# H2Teesside Project

Planning Inspectorate Reference: EN070009

Document Reference: 1.7 Applicant's Response to S51 Advice and S55 Checklist

Date: May 2024

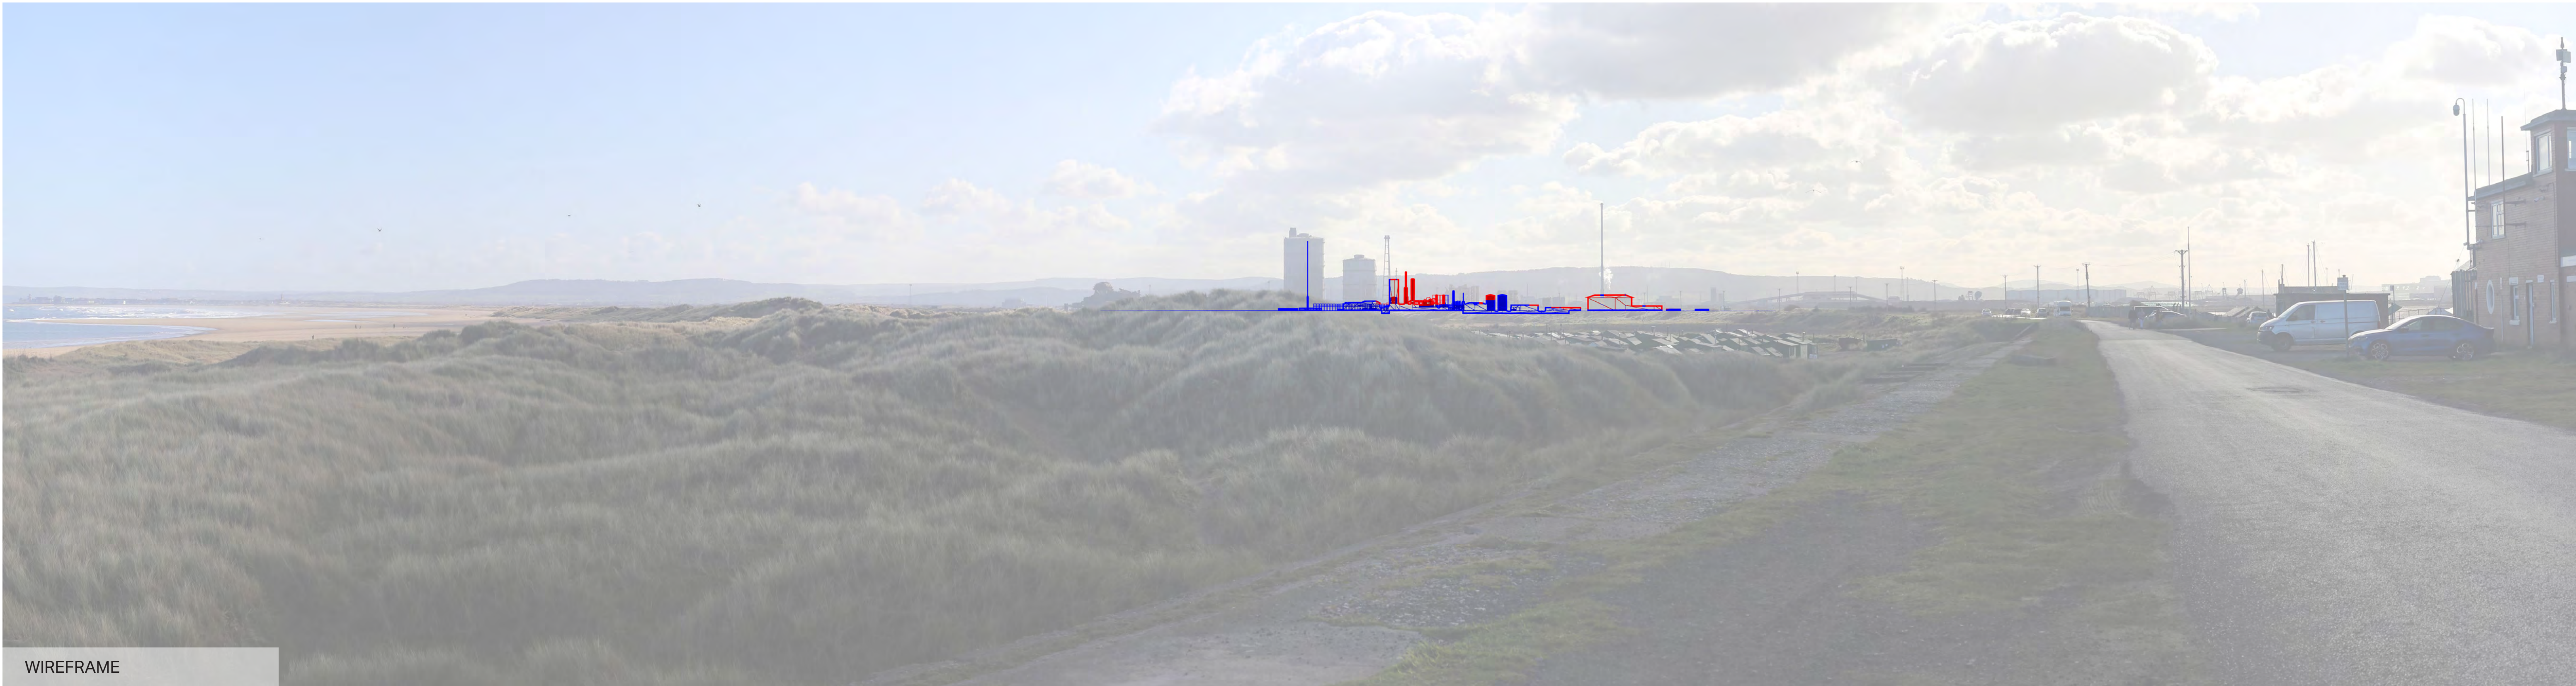
NO.	SECTION 51 ADVICE/COMMENTS	APPLICANT'S RESPONSE/UPDATE	WHERE THE INFORMATION CAN BE FOUND/DOCUMENT REFERENCE
	<p>consented Net Zero Teesside project.</p> <ul style="list-style-type: none"> <li>○ Isometric views and elevations to be updated to include indicative landscaping.</li> </ul>		
2	<ul style="list-style-type: none"> <li>● Updated indicative pipeline plans to show:                             <ul style="list-style-type: none"> <li>○ Typical elevation of above ground pipelines in context with surrounding features.</li> </ul> </li> </ul>	<p>Typical elevations of the above ground pipelines will be submitted prior to the start of Examination.</p>	n/a
3	<p><b>Photomontages:</b></p> <ul style="list-style-type: none"> <li>● Update to the photomontage document to include revised base photography showing the current views of the site, or explain why this is not possible or signpost where in the submitted documents you have explained why up to date baseline photography has not been used.                             <ul style="list-style-type: none"> <li>○ Please provide a photomontage document that labels the main features of the proposed development in, as a minimum, the 'wireframe' view</li> <li>○ Please provide a version of the photomontages, using the same</li> </ul> </li> </ul>	<p>The Applicant recognises that the Site and its surroundings have continued to evolve over the course of the Environmental Impact Assessment (EIA) period. Revised photomontages using updated base photography will be prepared to inform and update the assessment and submitted prior to the start of the Examination.</p> <p>Document Reference 6.3.93 has been renamed 'Figure 16-7-1a to 16-7-4f: Photomontages' and contains the following changes.</p> <p>Figures 16-7-1a to 16-7-4c have been amended to include labels for the main</p>	<p>'Figure 16-7-1a to 16-7-4f: Photomontages' (Document Reference 6.3.93, Revision 1) has the following changes:</p> <ul style="list-style-type: none"> <li>● Figures 16-7-1c to 4c updated with features of the Proposed Development.</li> <li>● Addition of new figures:                             <ul style="list-style-type: none"> <li>○ Figures 16-7-1d to 4d with NZT wireframe added.</li> <li>○ Figures 16-7-1e to 4e 200% zoom in of the Proposed Development only.</li> <li>○ Figures 16-7-1f to 4f 200% zoom in of the Proposed</li> </ul> </li> </ul>

NO.	SECTION 51 ADVICE/COMMENTS	APPLICANT'S RESPONSE/UPDATE	WHERE THE INFORMATION CAN BE FOUND/DOCUMENT REFERENCE
	<p>viewpoints as the current photomontages, at 200% enlargement detailing the Proposed Development with and without the consented Net Zero Teesside project.</p>	<p>features of the Proposed Development in the 'wireframe' view.</p> <p>Photomontages are intended to be viewed by printing at A1 on a long sheet and be equivalent to the eye view of the development from the viewpoint. Any change to this such as a 200% enlarged view will not conform with approved guidance and cannot be referred to as a photomontage.</p> <p>Document Reference 6.3.93 includes new figures which have been prepared to show the photomontage views with the Proposed Development and NZT (Figures 16-7-1d to 4d), 200% zoom visualisations of Proposed Development only (Figures 16-7-1e to 4e) and 200% zoom visualisations of Proposed Development and NZT (Figures 16-7-1f to 4f).</p>	<p>Development and NZT wireframes.</p>
